UNION PRECINCT

Submission - Shore Physical Education Centre. SSD 7507

BISHOP'S GATE CAR PARK &
RECONFIGURED DROP OFF/PICK-UP DESIGN

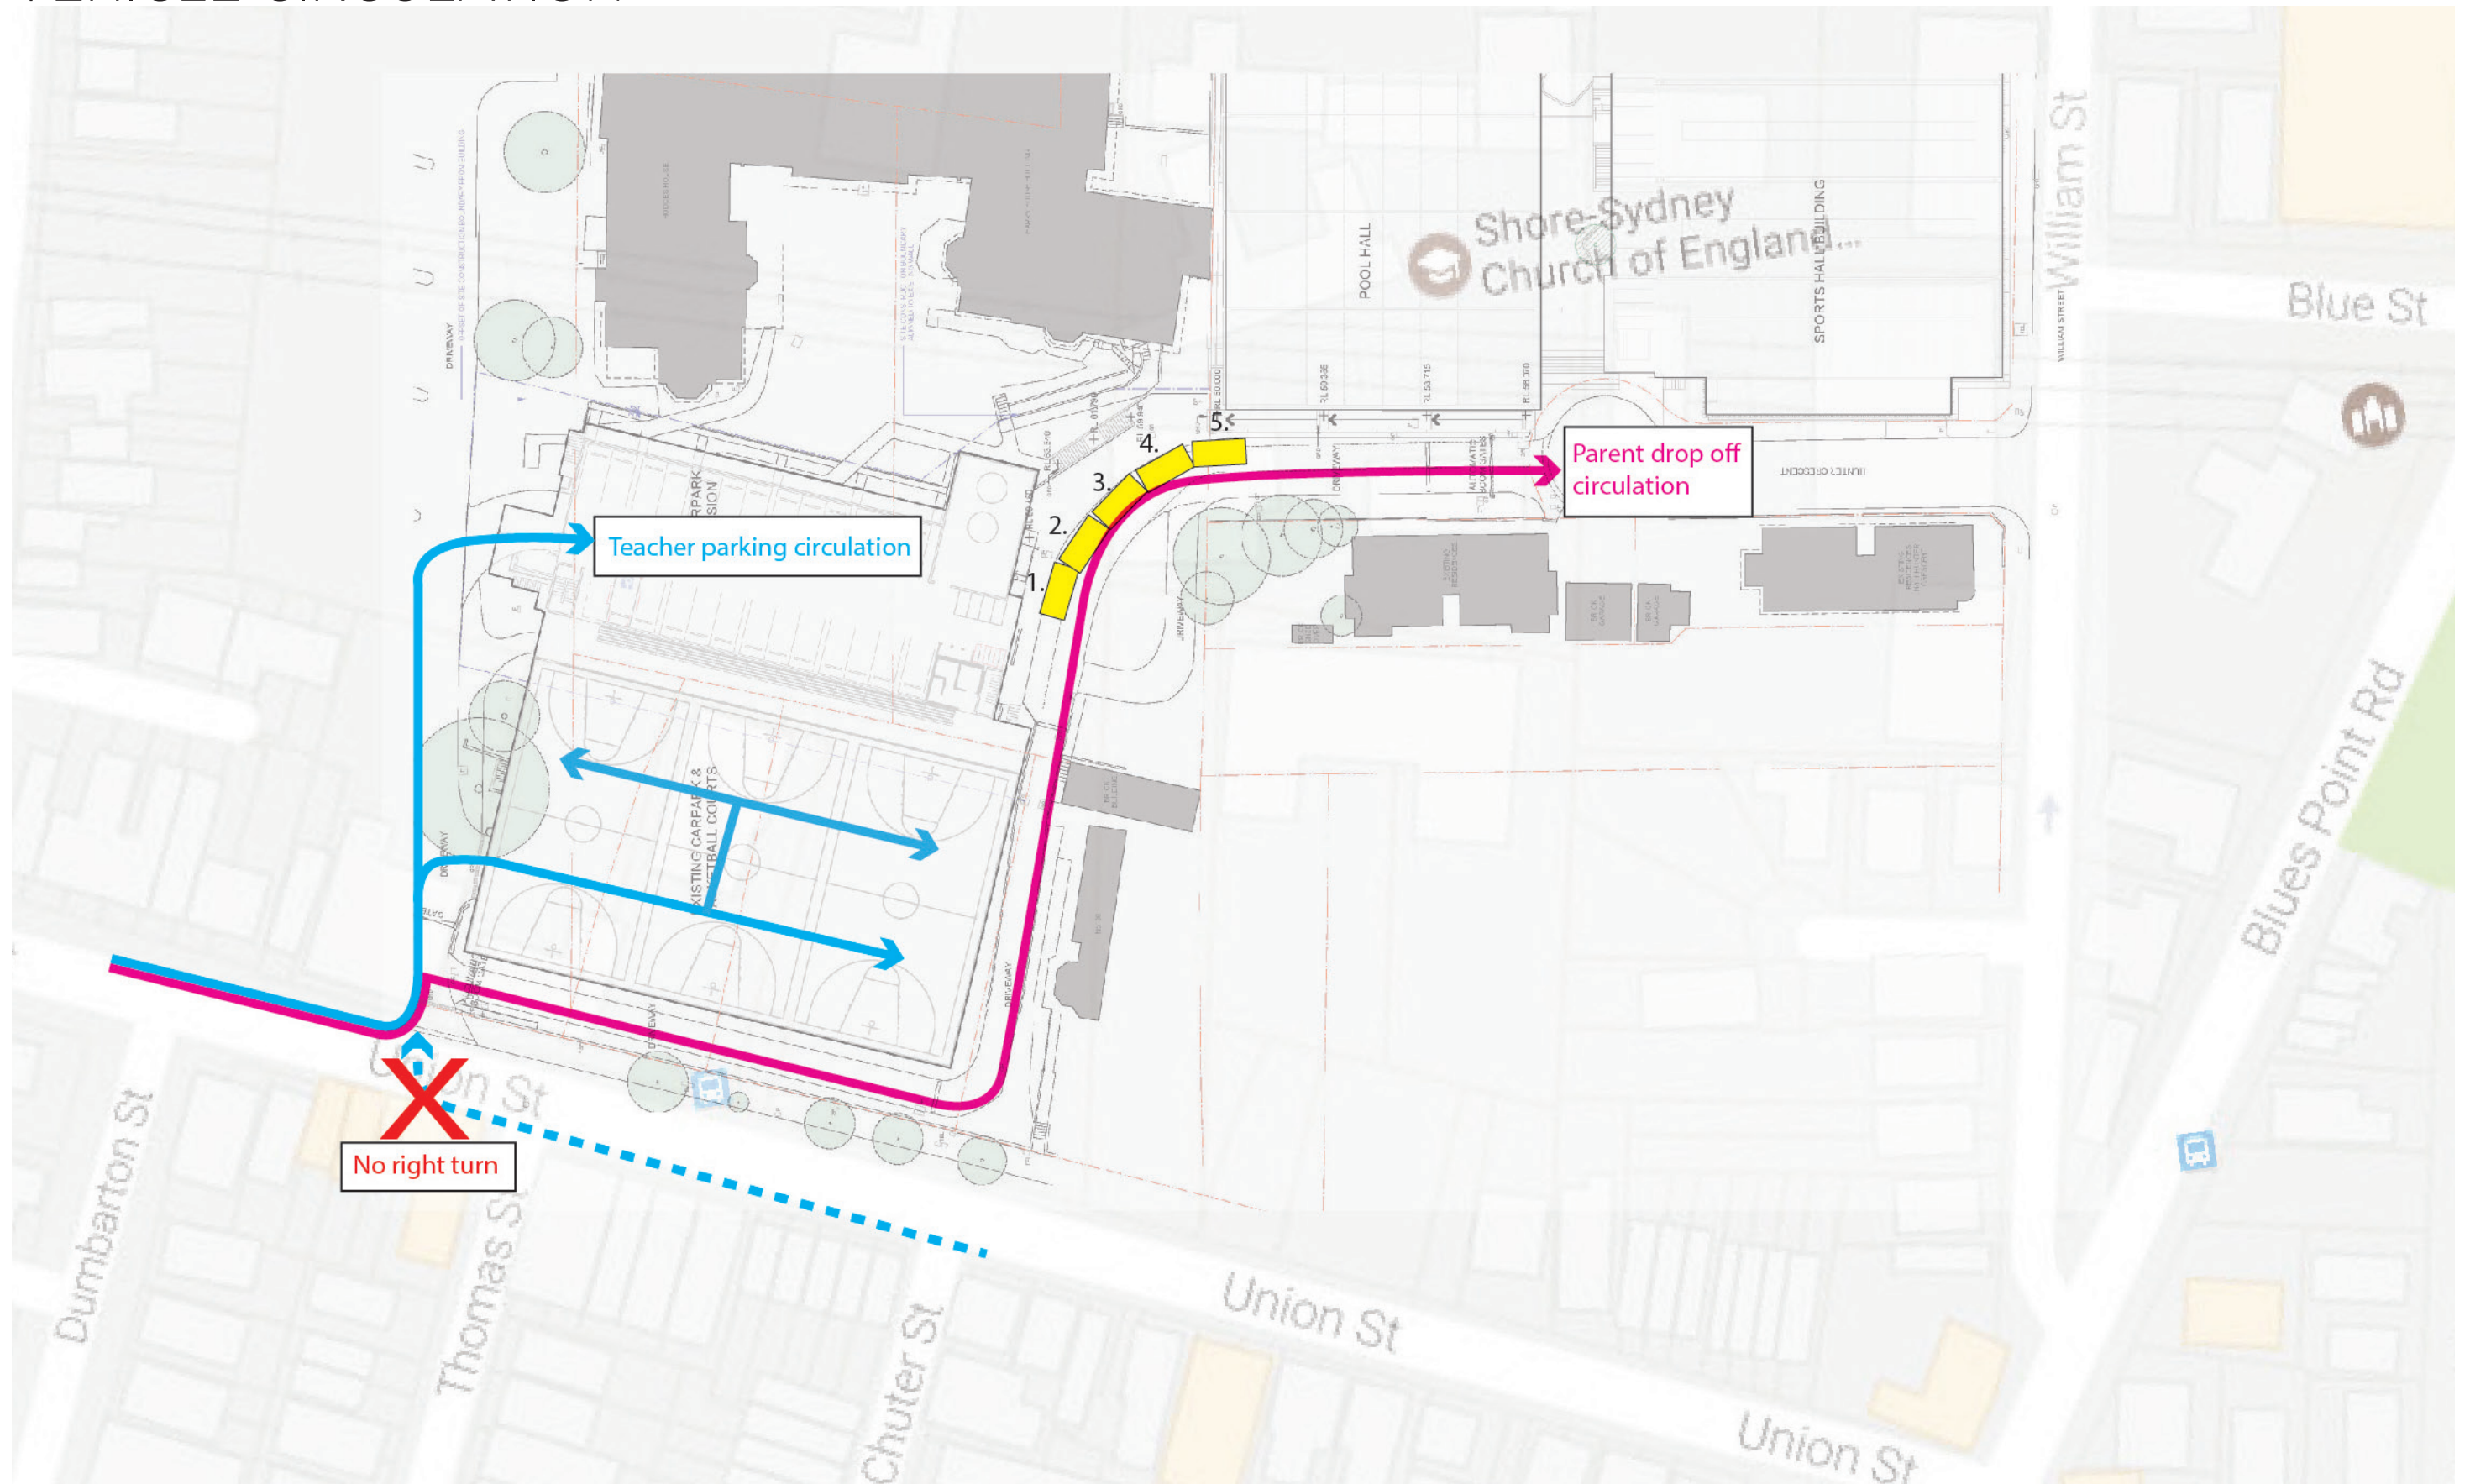
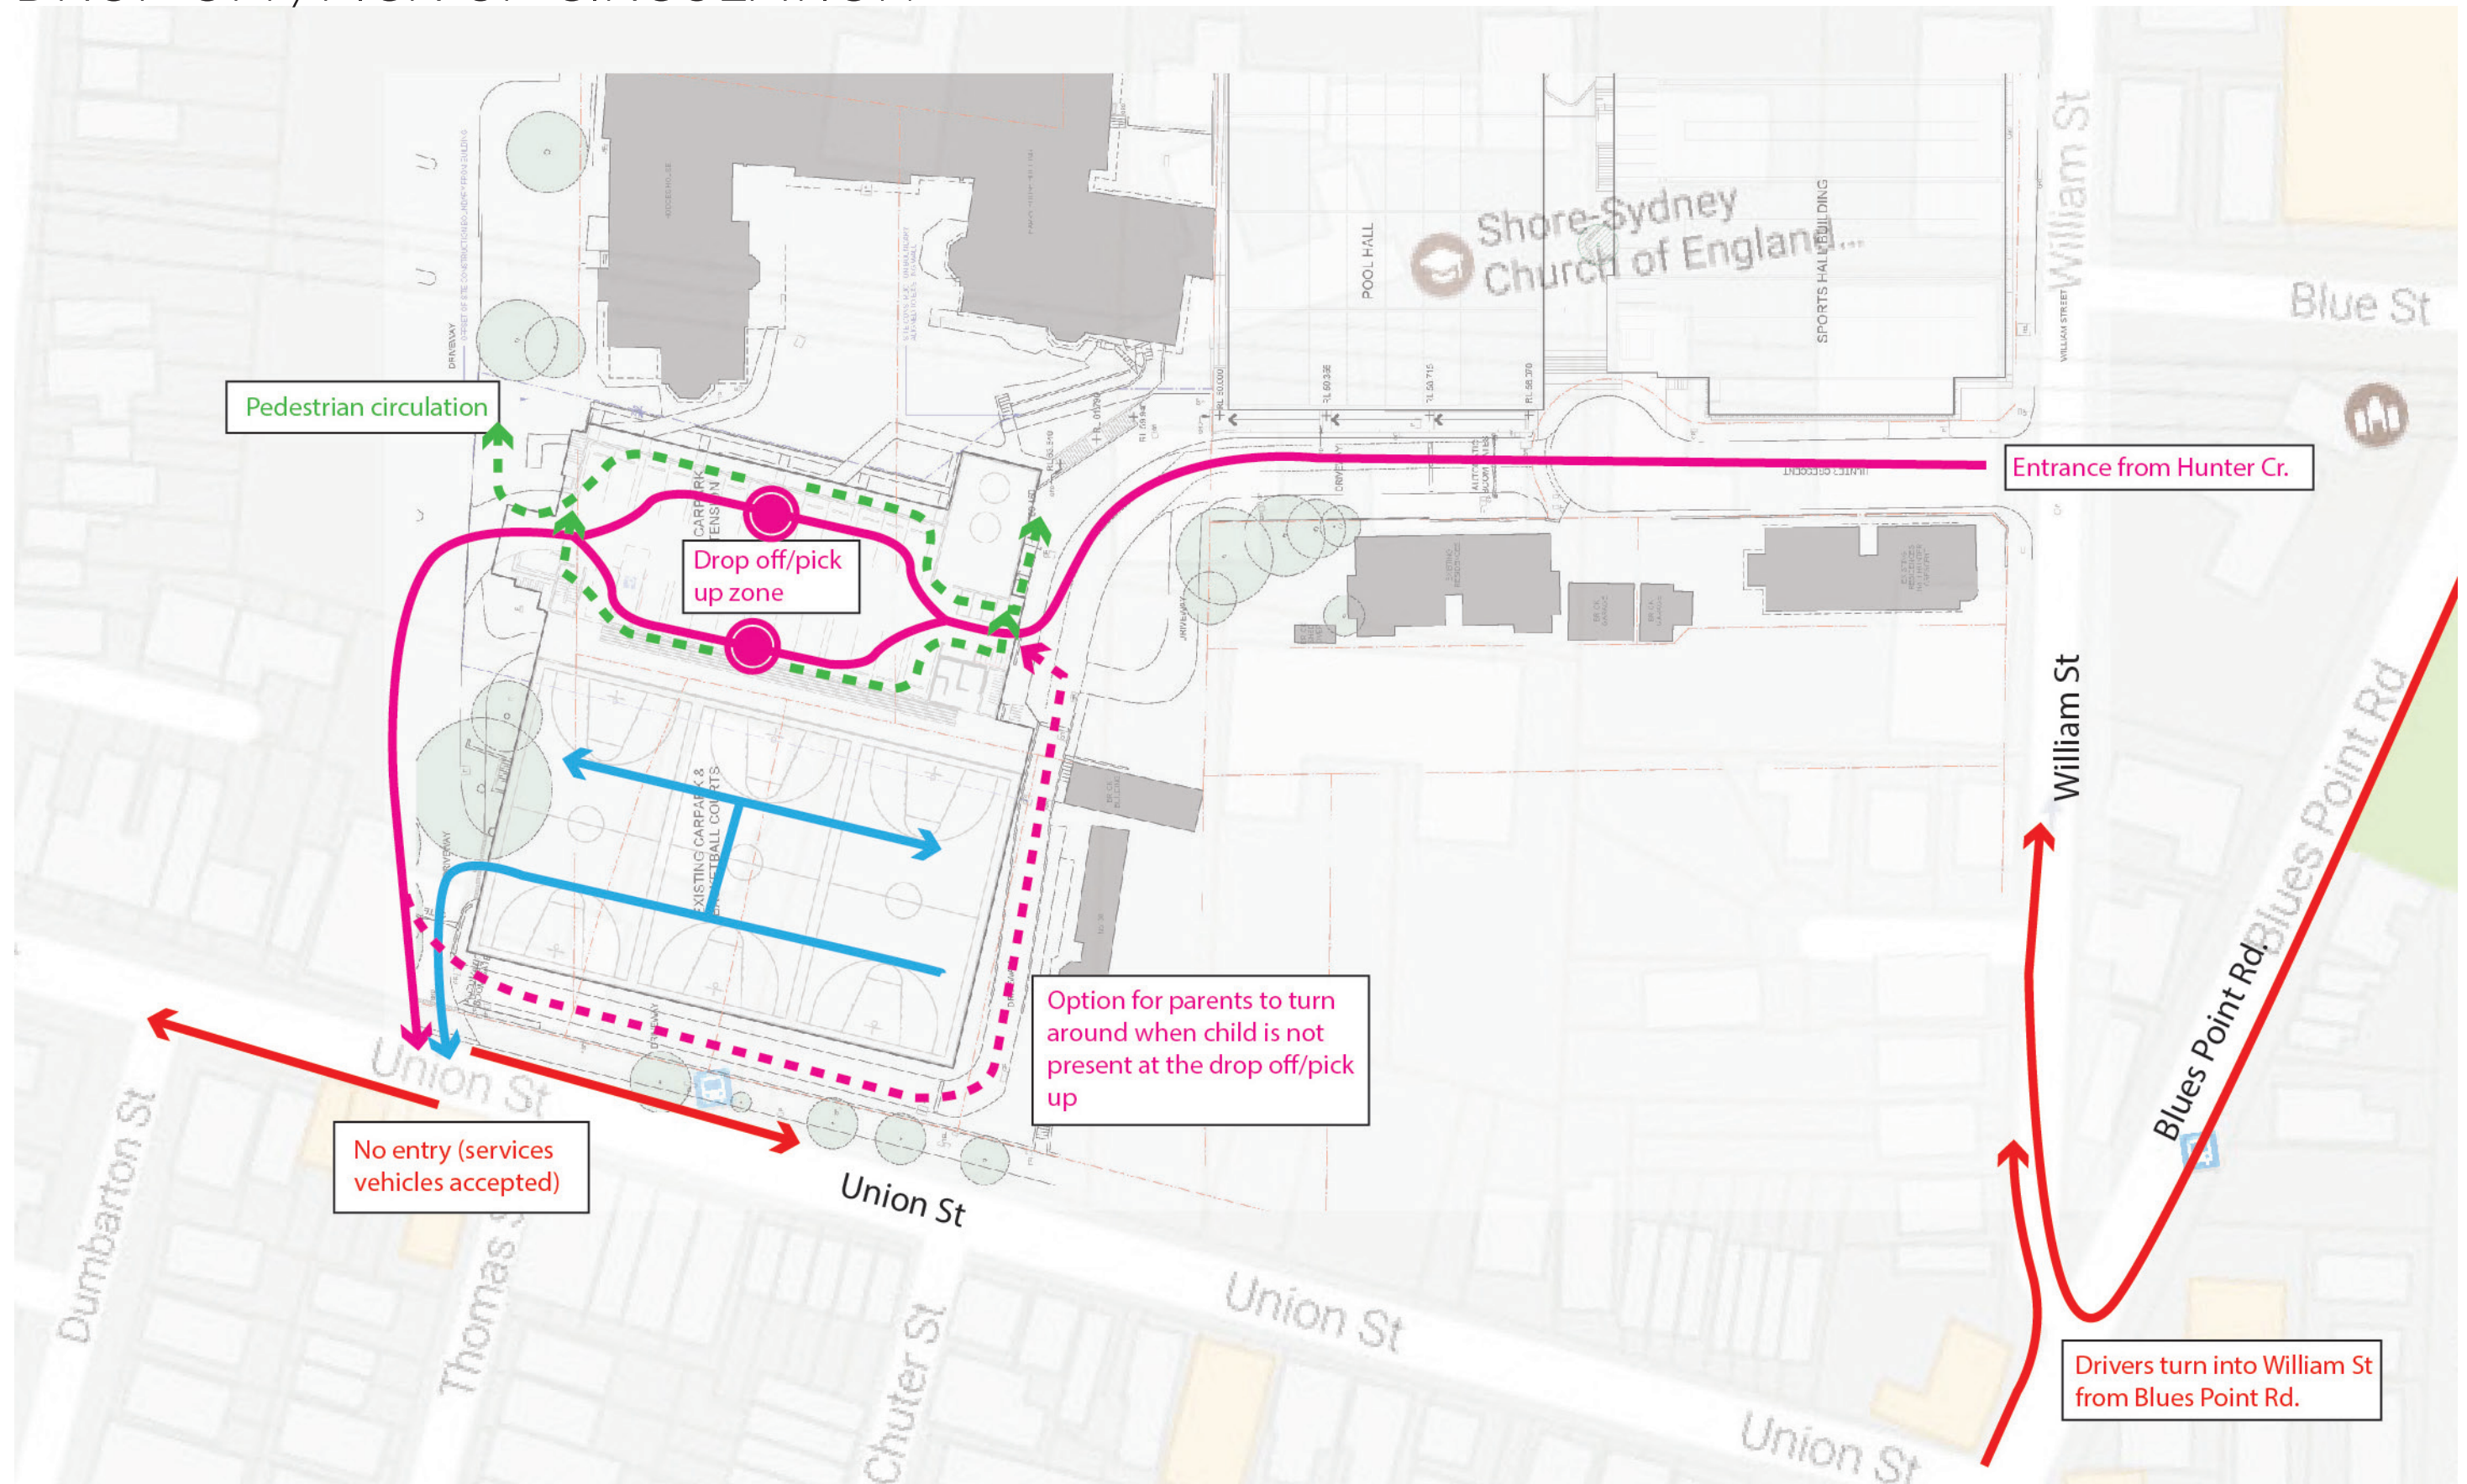
The Precinct's major concern is that of **traffic management, and especially the long term arrangements for Union St.** North Sydney Council, as a condition of a previous Development Consent, banned Right Turns from Union St into the "kiss and drop facility" driveway. Signs were erected accordingly, but observations from the residents on the south side of Union St clearly show that the ban is not being followed, nor policed.

The problem arises as the single driveway entrance from Union St is a shared driveway with 3 functions;

- entry to the drive heading north to behind the Dining Hall and other buildings, used for staff parking and service vehicles and food supply vehicles
- entry into the existing staff parking structure
- entry into the kiss and drop access drive by virtue of a hard right turn once in the driveway.

Clearly, it is impossible to police an illegal right turn into a driveway when 2 out of the 3 activities are legal. Right turns at the top of the Union St hill also are a dangerous activity - afternoon sun glare is a serious issue, route 265 buses cannot pass as parking as allowed on the south kerb, and long queues are not uncommon in the afternoon pick up.

In previous submissions to North Sydney Council, the Precinct has consistently called for access into the Union St drive entrance to be LEFT HAND TURN only, with a painted medium strip and/or double lines installed to encourage that.

This development application increases the staff parking structure numbers by 38 additional cars, with the only access from the existing opening for the Union St driveway. So traffic activity is clearly increased at a critical point - the right turn into the Union St driveway. These increased traffic movements result in the Precinct formally repeating our previous demands that, as a Condition of Consent, a condition be inserted as follows -

" Access into the Union St eastern driveway will be LEFT HAND TURN ONLY, and the entrance will now be signposted on both sides accordingly, and a painted and striped medium strip will be installed on the verge of Union St carriageway to enforce correct use of the driveway entrance"
